# Planning Inspectorate

Project ref: EN010141

### **Application by BSSL Cambsbed 1 Ltd for an order granting development consent for the East Park Energy project**

#### **Advice following issue of decision to accept the application for examination**

Figure 8c: Flood Map for Planning Flood  
Zones plus Climate Change for 2080s  
epoch (Grid Connection)

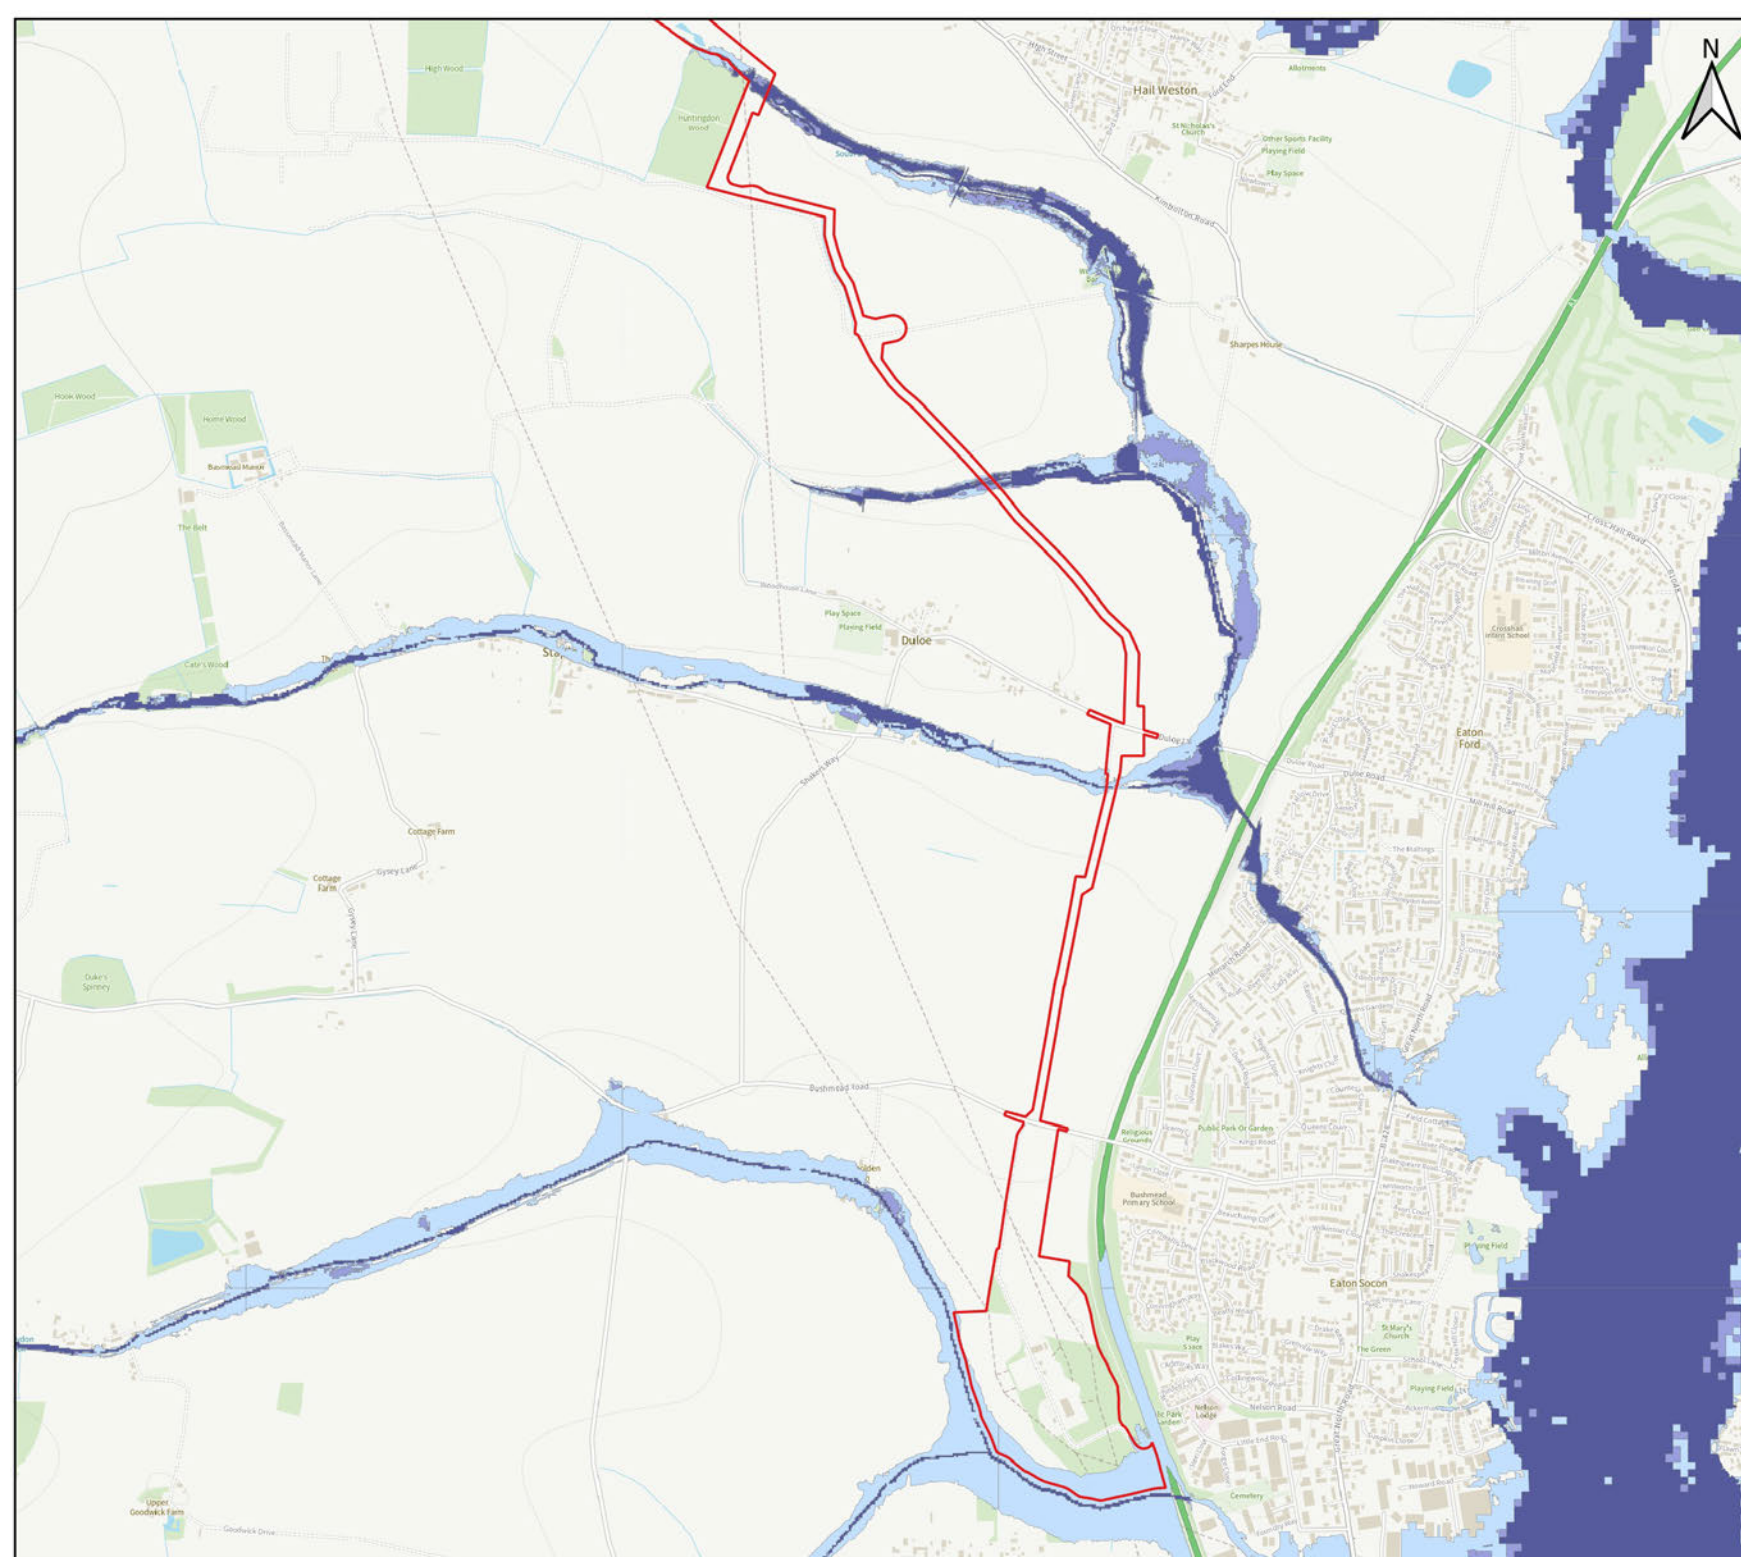
Figures 7a, 7b, 7c, and Figures 8a, 8b, and 8c of the FRA show the maps with RoFRS and RoFSW with climate change allowances for the 2050s epoch although the proposed development is anticipated to have a lifetime of 40 years up to 2070. The applicant to provide revised figures to show RoFRS and RoFSW with climate change allowances up to the 2070s epoch should be sought.
